From: [William Simcock](#)
To: [DCAdmin](#)
Subject: FW: Councillor comments 2020/622/91337/W - 1A Mount Pleasant Lane - Almondbury Ward
Date: 14 July 2020 11:53:29
Attachments: [1A two parking places.jpg](#)

From: Cllr Alison Munro
Sent: 13 July 2020 19:21
To: William Simcock <William.Simcock@kirklees.gov.uk>
Subject: 2020/622/91337/W - 1A Mount Pleasant Lane - Almondbury Ward

PROPOSED BLOCK PLAN
1:500

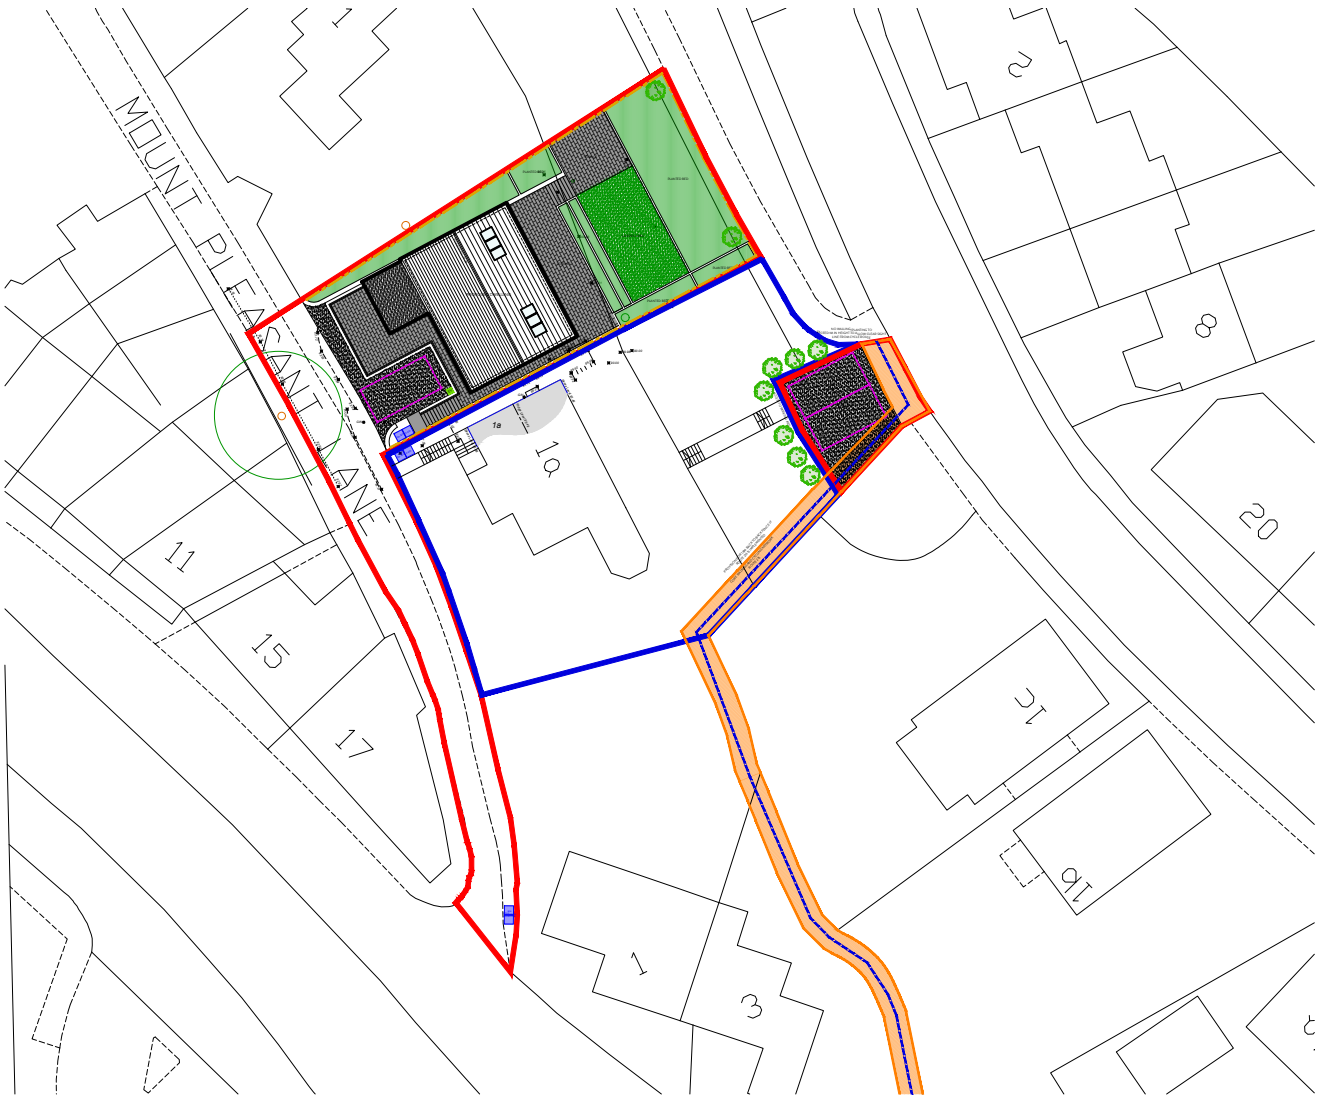
You will note from the plans that one parking place is shown at the front of the existing property on Mount Pleasant Lane and two at the rear of the existing property. The issue is this in that the two parking places shown on the plans at the rear of the property do not currently exist and it would be impossible to even get a car to the rear of the property as the property itself is about 3 meters up a steep banking with under garden parking at the front in the form of a double garage which easily allows for two cars to park there. Please see my photo.

Additionally as there is no possible way for a car to access the rear of the property, a new access entrance will be required off Fenay Bridge Rd. On the planning application it says the owners are creating only one additional parking place and no new access will be required. Both these statements are I believe therefore false and I am not happy about this as I feel someone is trying to mislead both residents and officers.

The plans show only one property not two, so please can you clarify this as the shape of the house included in the plans does not resemble the current existing house.
